### **Ecological comments**

Planning Application No: **3/2014/0438**

Proposals: **Development of 106 residential units, including affordable housing, new vehicular and pedestrian accesses, landscaping, public open space and ecological enhancement measures**

Location: **Land East of Chipping Lane**

Drawing:
Boundary Treatment Plan

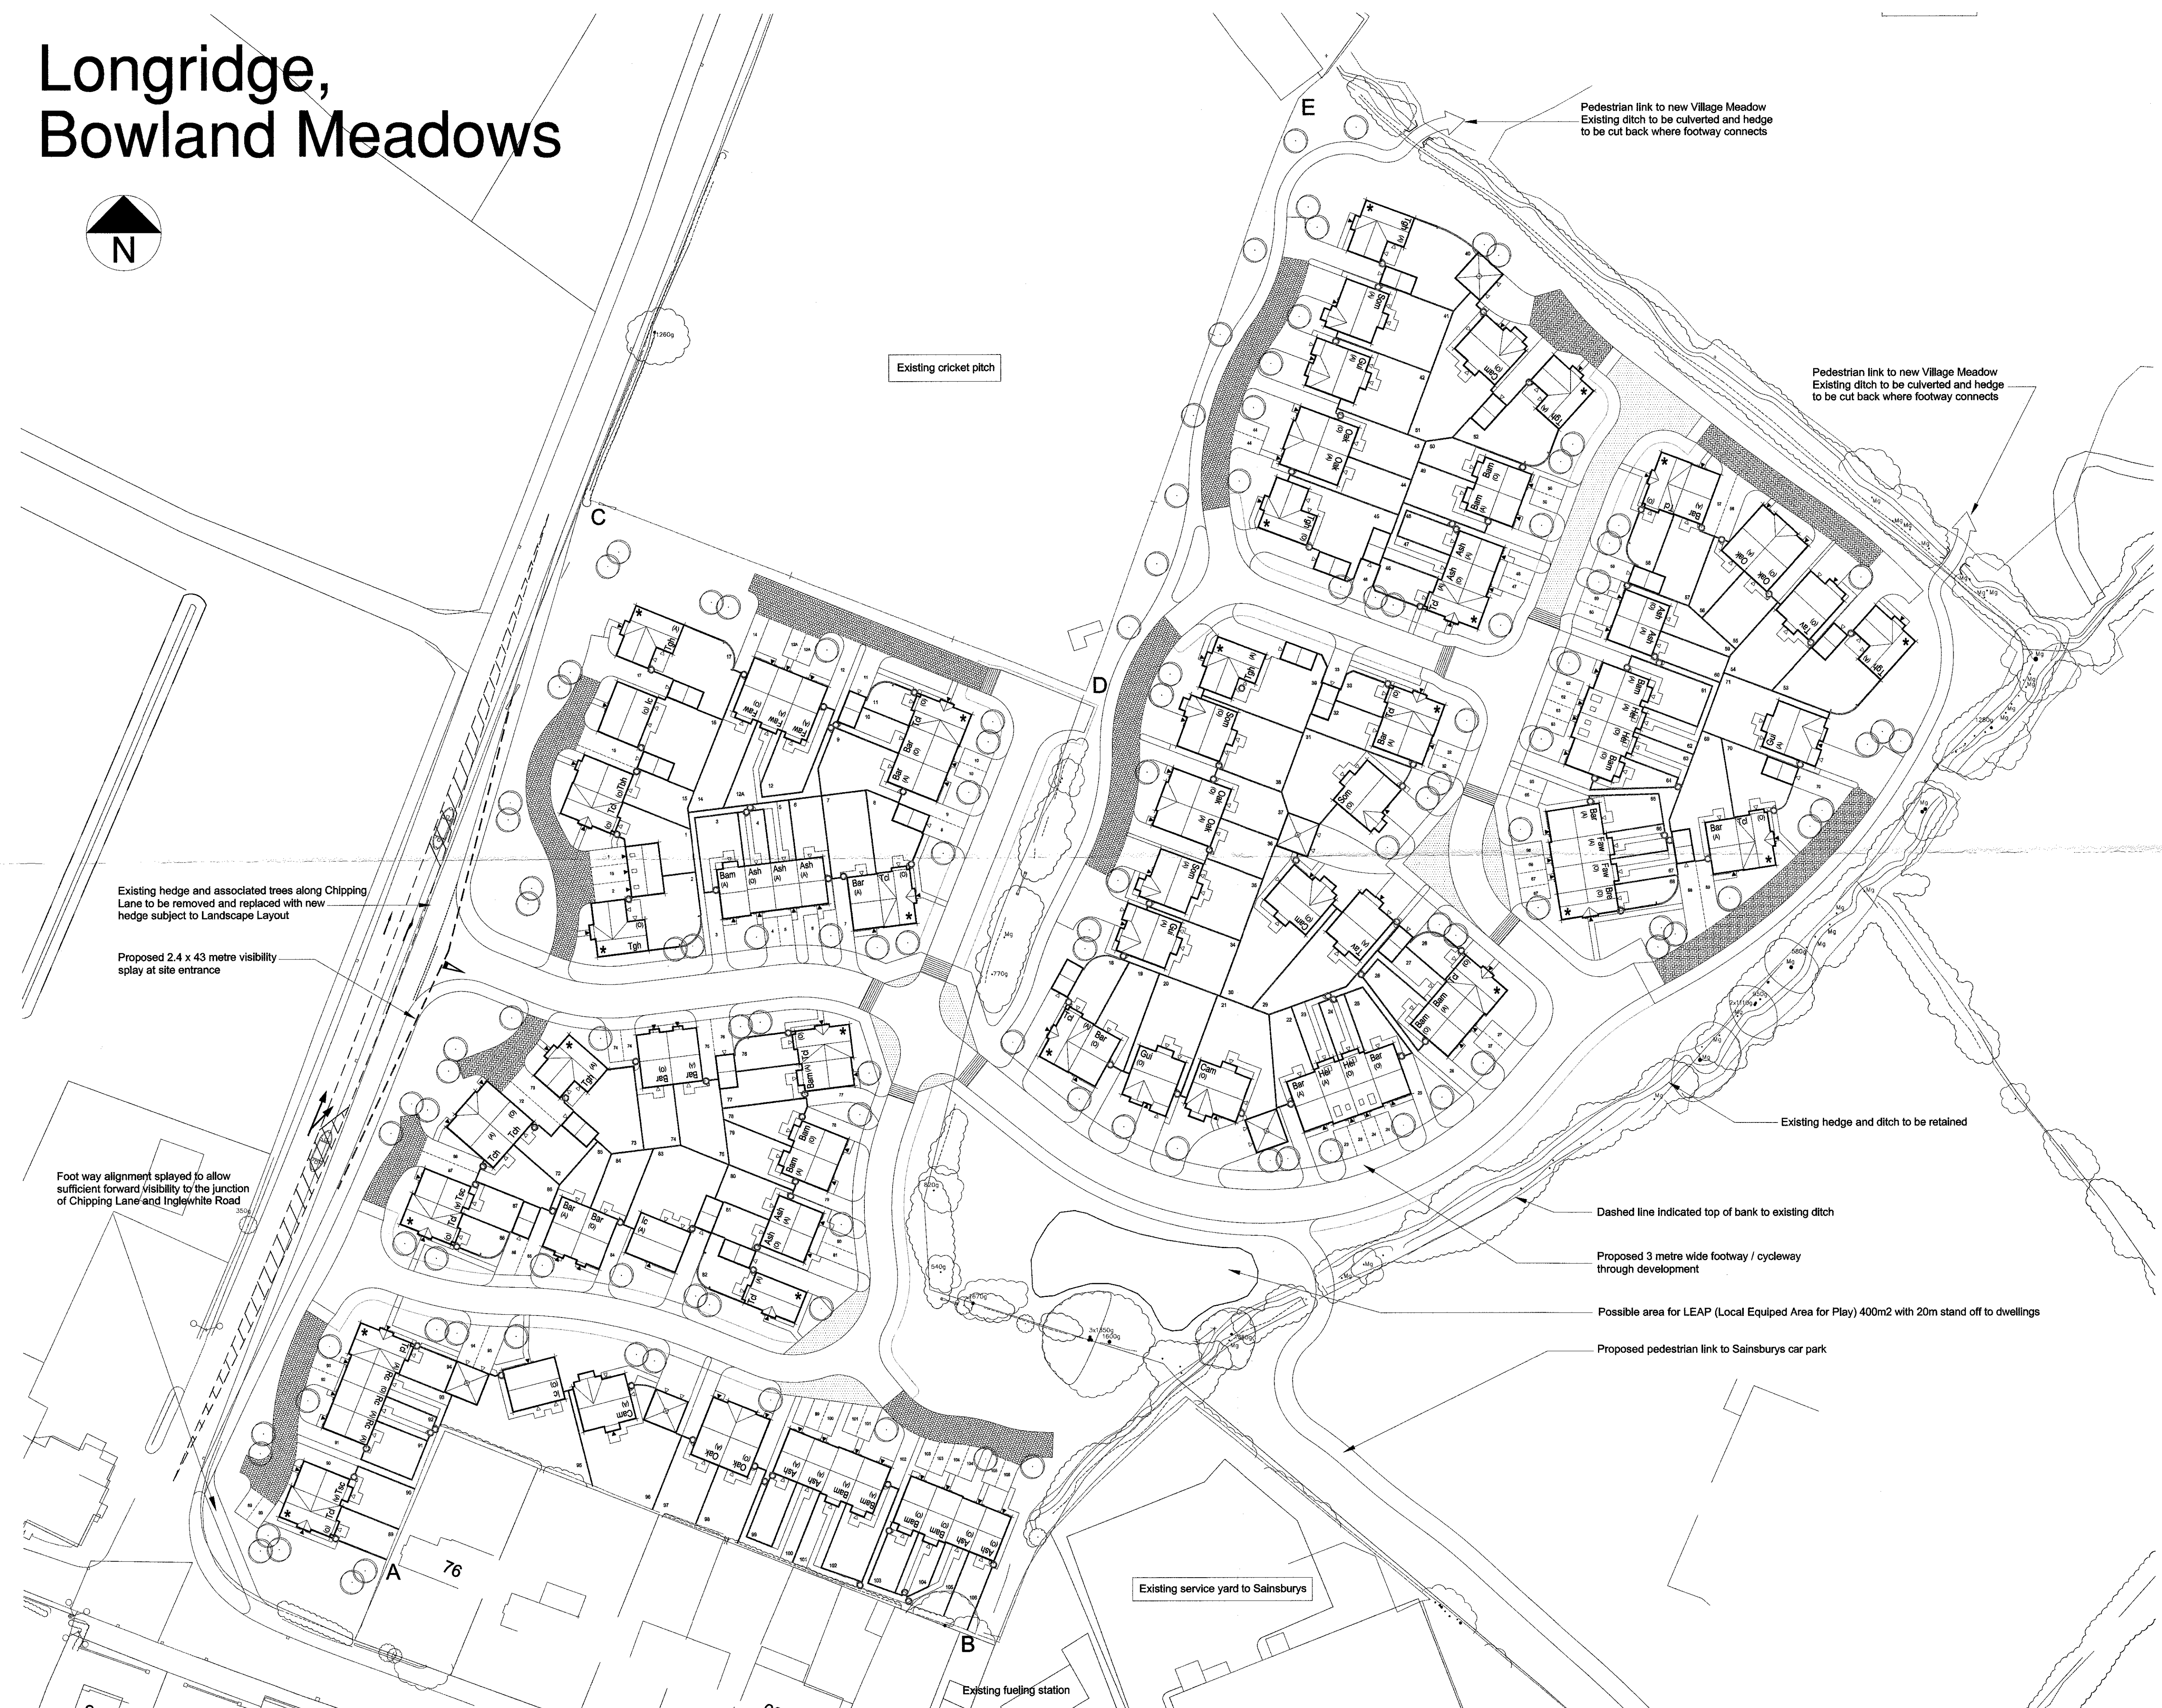
- Information to address my previous comments regarding bat roosts and trees has not been submitted. Following contact with the applicant's Ecologist I understand that close inspection of the 3 trees along the site frontage (to be removed) has not yet been carried

Unless impacts on the 3 trees along the site frontage (both direct and indirect impacts) can be avoided, then the results of further surveys to establish the presence/absence of bat roosts will need to be submitted prior to determination of the application.

- In order to retain habitat connectivity through the site, for example for Species of Principal Importance such as hedgehogs, boundary treatments should be raised from ground level by 0.15 to 0.2 metre or suitably sized gaps should be left at strategic points.
